Our ref: *D2020/68595*

SSD 10404 Horsley Drive Business Park Stage 2 – Building 1 – Response to Submissions

Thank you for your email dated 26 June 2020 seeking WaterNSW's comment on the response to submissions (RTS) report for the above development.

Figure 2 SSD10404 proposed works and the Upper Canal

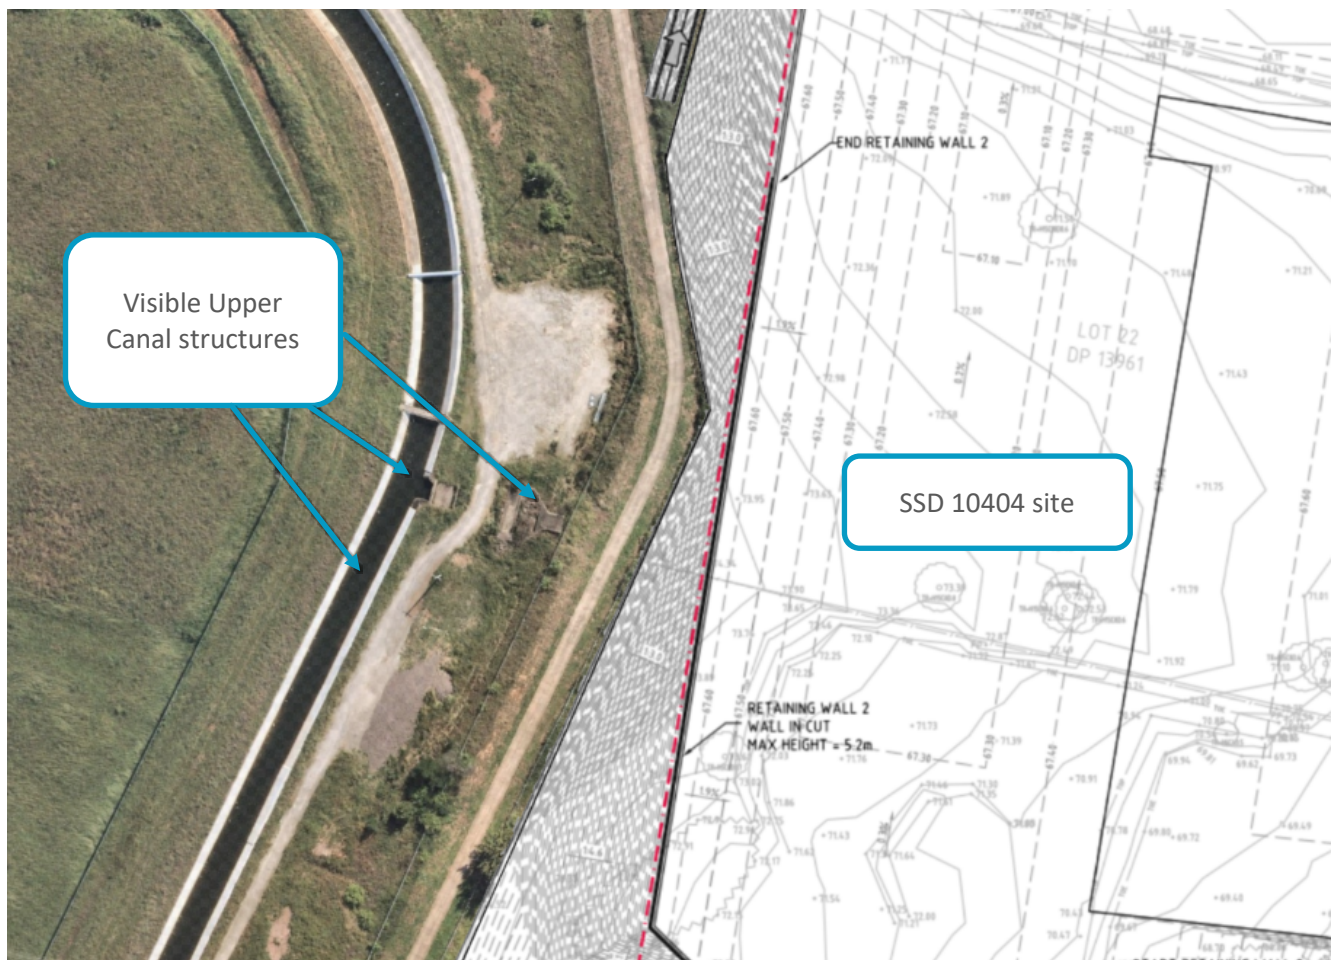
WaterNSW made an incorrect reference in our response advice to the EIA review. This relates to the table reference within the current German Standard "DIN 4150 – Part 3 - "Structural Vibration Part 3: Effects of vibration in structures". Reference should be made to table 1, not table 3. WaterNSW accepts that the applicant undertook considered review of our comments and made the required changes in the RTS documents.

The vibration limit agreed to by the applicant of 50mm/s refers to the limits applied in the incorrect table. The applicable value is 8-10mm/s (50-100 hertz) from line 3 of table 1 of the current German Standard "DIN 4150 – Part 3 - "Structural Vibration Part 3: Effects of vibration in structures".

- *Vibration criteria be established in the Construction Environmental Management Plan (CEMP) of 8-10mm/s at the Upper Canal structure, to manage vibration at this sensitive asset.*
- *The stormwater system for the site must be designed so as not to either impede upstream flows from the Upper Canal corridor or stormwater structures, nor result in increased flows onto WaterNSW land from the site.*
- *WaterNSW should be provided with the details of the proposed earthworks, retaining walls or other construction along the boundary of the Upper Canal corridor before such works*
